Fore Street

Jeff Tarling <jst@portlandmaine.gov>
To: Jean Fraser <jf@portlandmaine.gov>

Wed, Mar 16, 2016 at 4:54 PM

In review of the proposed 31 Fore Street project offer the following recommendations:

TREE PLANTING DETAIL
NOT TO SCALE

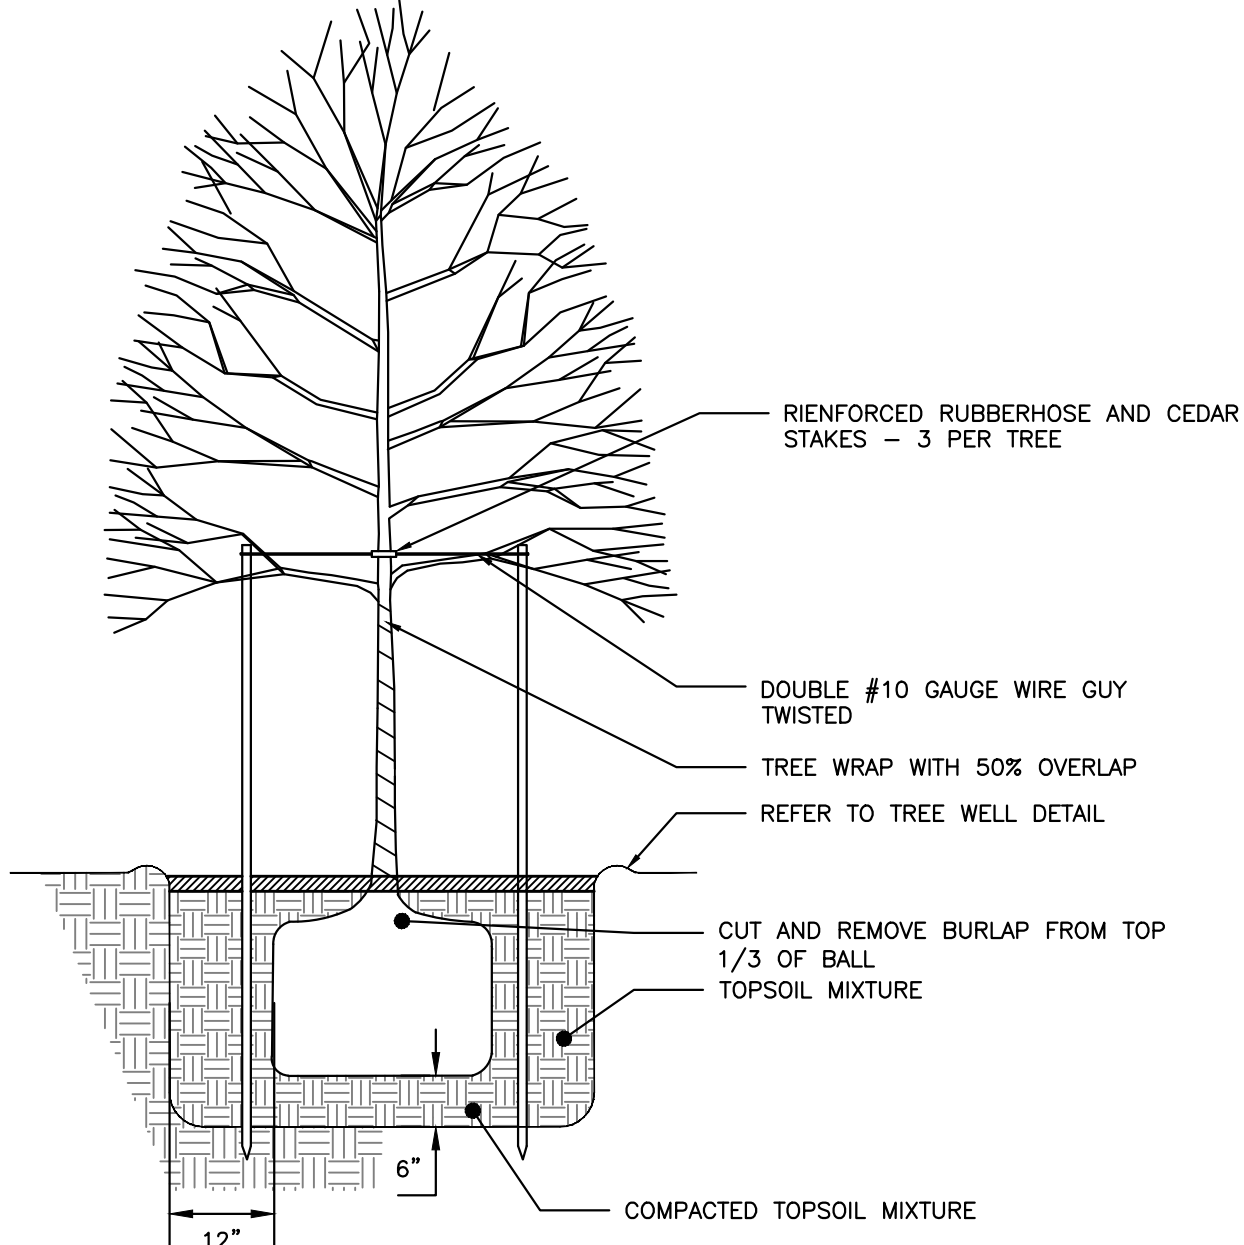
Street trees - The two new street trees proposed for Waterville Street should be 'Autumn Gold' Ginkgo 2" caliper, planted in 4 x 7' tree cut outs in the walk. Exact tree locations should match the 'in-between' spaces for any on-street parking to help avoid door openings into the tree trunk.

TREE PROTECTION DETAIL
NOT TO SCALE

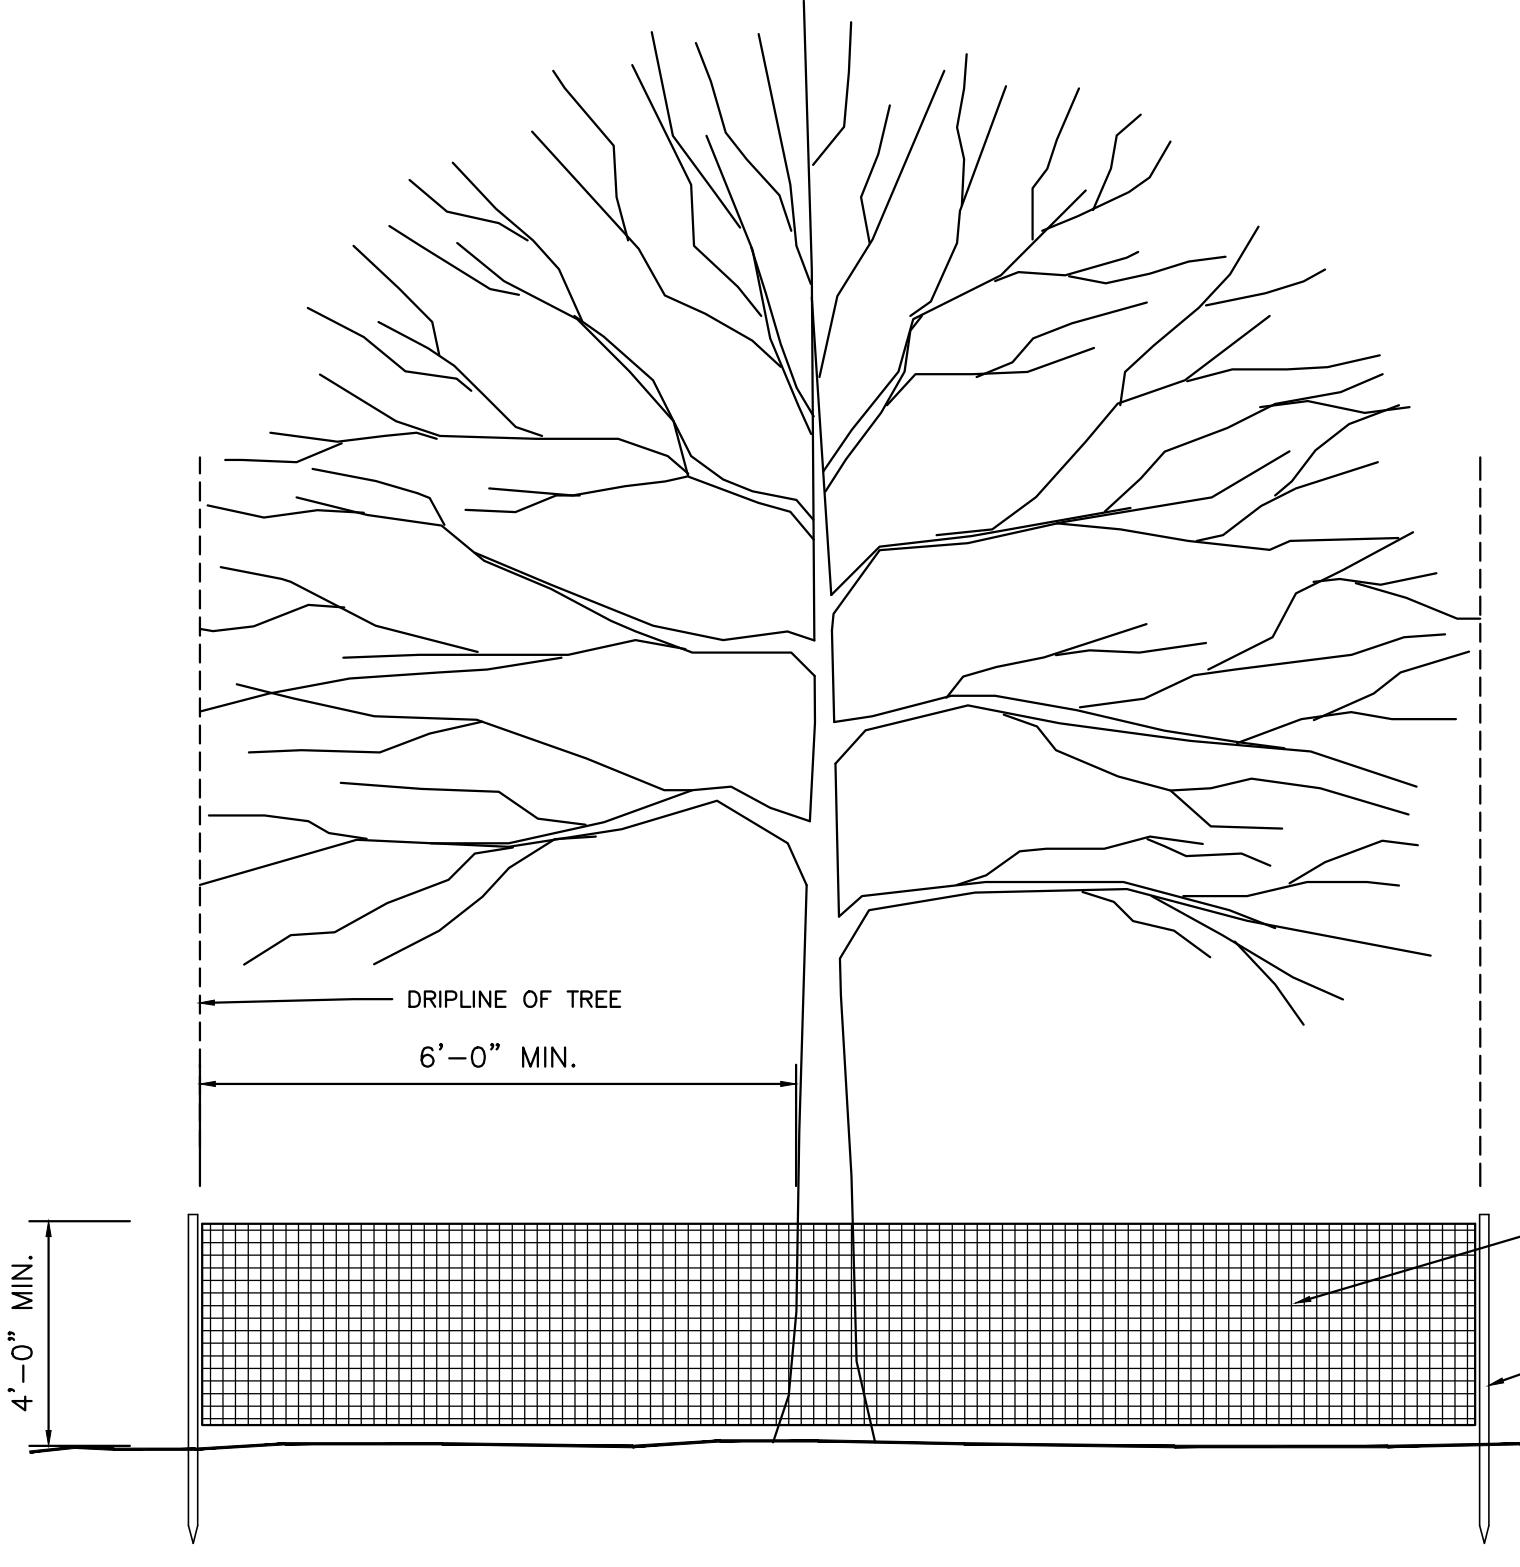
The existing Honeylocust on Fore Street which is 15' east or uphill from the fire hydrant is in good condition and will require 'tree protection' during construction. This should include trunk protection and orange construction fencing around the tree rootzone area. (Condition) The next uphill tree is about 25 feet east of the existing tree and no other space along the Fore Street frontage is open for tree planting.

The street tree along Fore Street should be protected during construction, any broken branches damaged should be pruned as part of the project.

SOIL FILTER CROSS SECTION

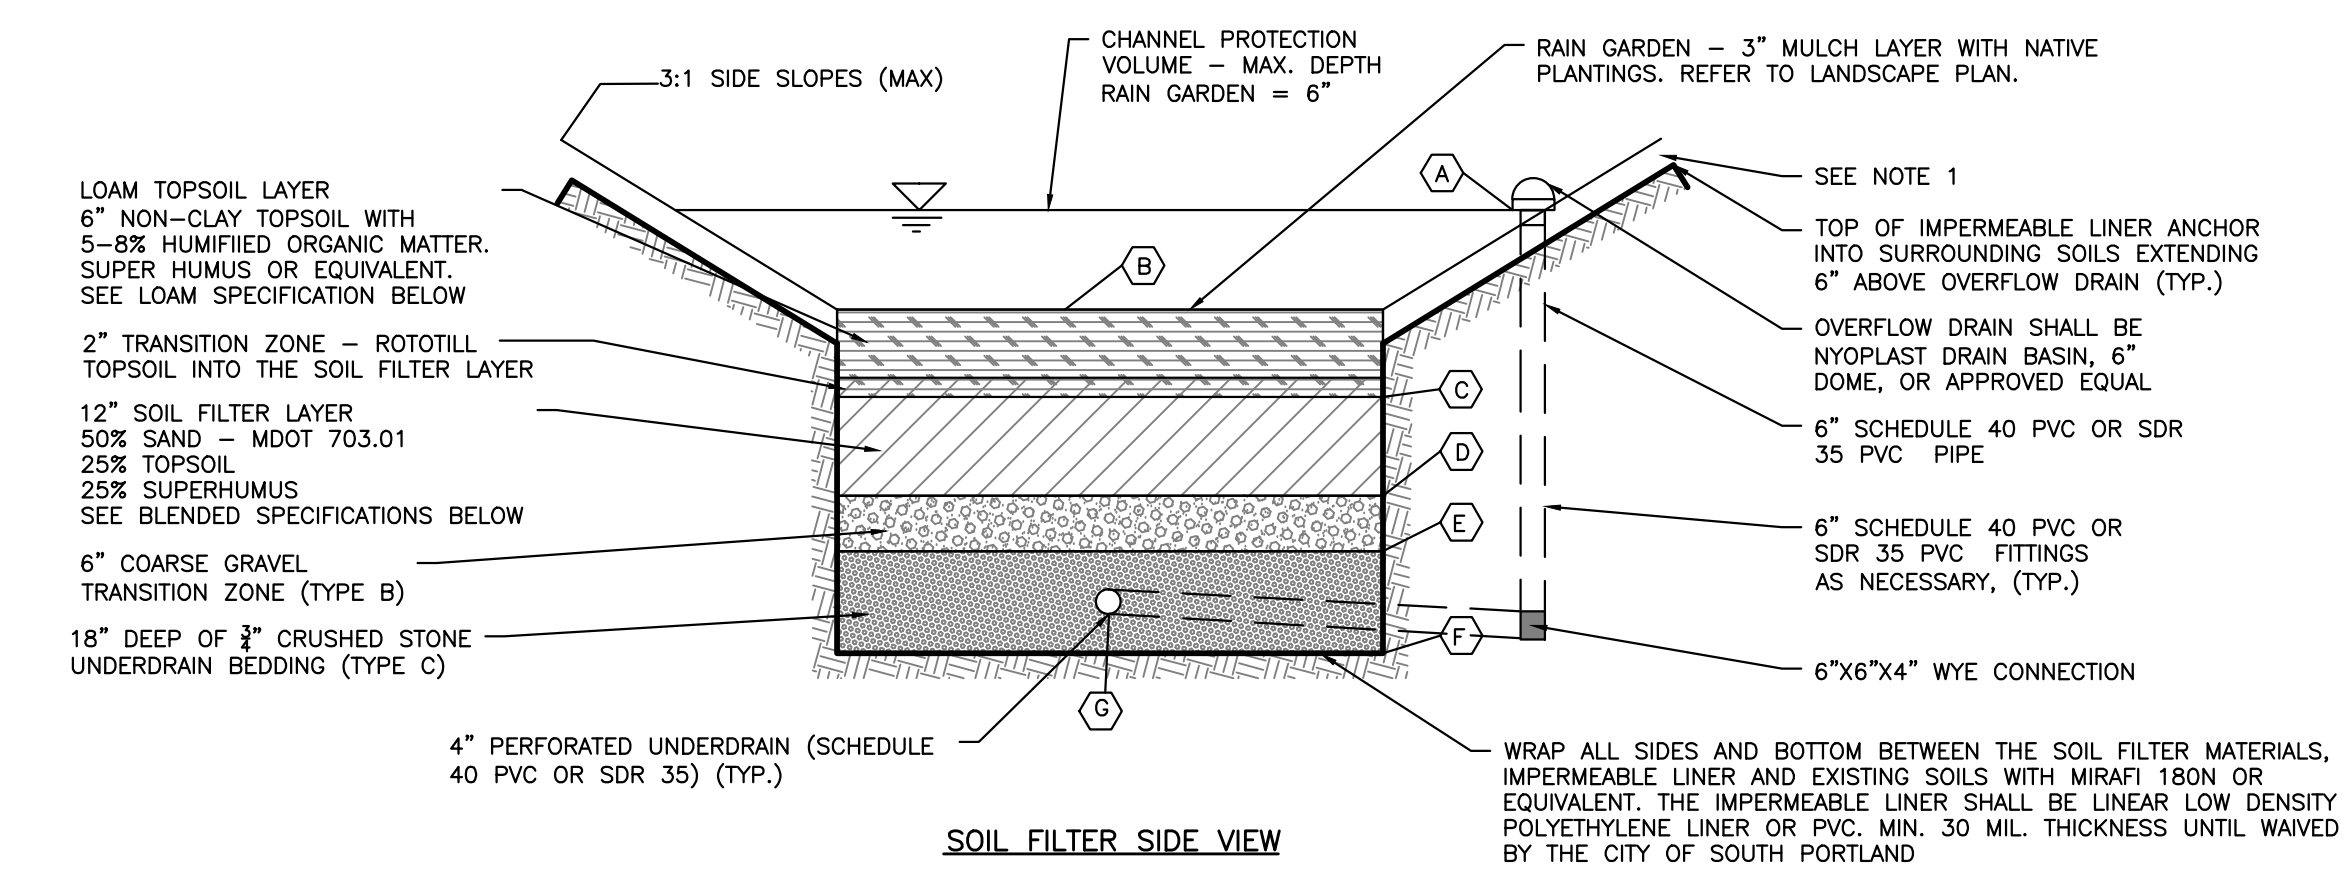
Rain Garden - Specific details on the rain garden are requested, if the project is to qualify for 'Stormwater' credits the project should follow Portland Water Resources 'rain garden' guidelines.
